Jeff Levine, AICP, Director
Marge Schmuckal, Zoning Administrator

September 25, 2012

RE: 42-54 Summit Street - 377-E-30 & 378-C-42 – (the “Property”) – R-2 Zone

Plan Depicting The Results Of A Boundary Survey & Proposed Lot Division Made For  
**Mony Hang**  
Southwesterly Sideline Of Summit Street & Southeasterly Sideline Of Bramblewood Drive  
Portland, Maine

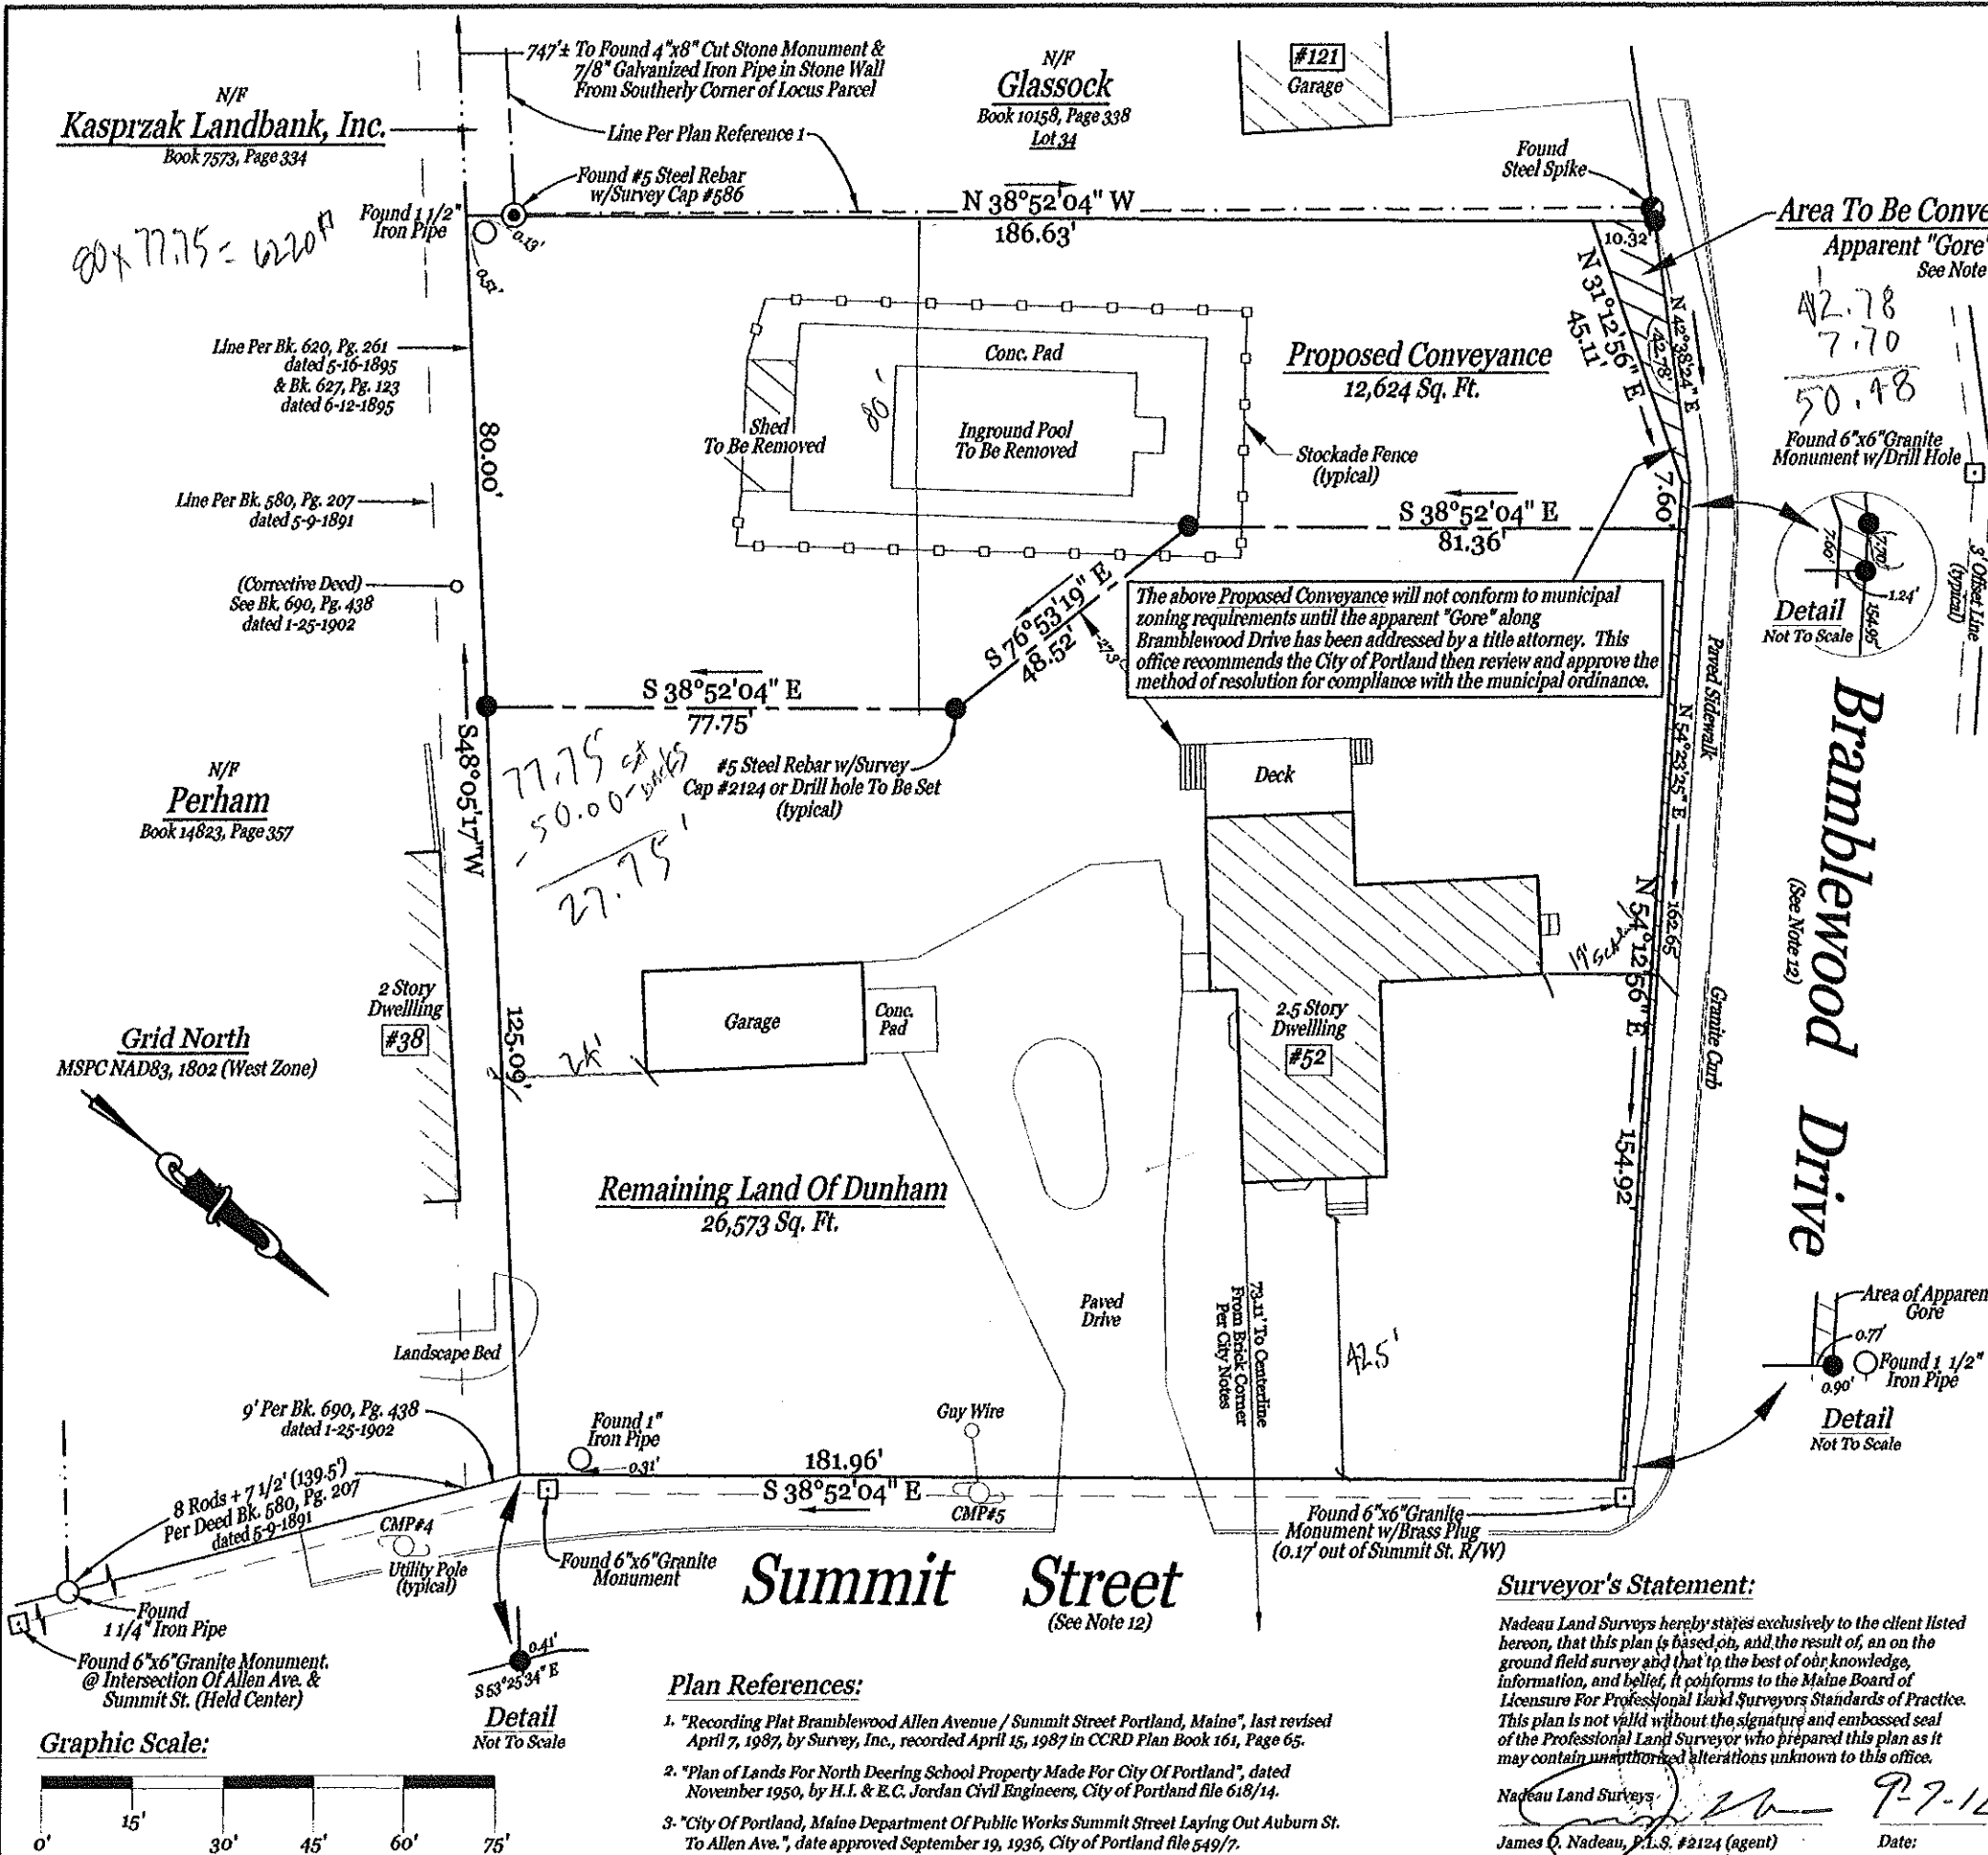
The division of land as shown results in both proposed lots (one with an existing dwelling along with the newly proposed vacant lot) meeting the underlying R-2 zone requirements, including but not limited to lot size, lot width and street frontage. However, the ability to legally transfer the proposed vacant lot is predicated on the requirement to remove the pool and concrete pad along with the fence and the removal of the shed.

Once the structure and pool are removed and the land title is transferred, separate permit applications are required for a new single family dwelling. This determination letter is not permission to proceed with construction. At that time an updated survey showing a proposed dwelling and it's setbacks to the property lines shall be required.
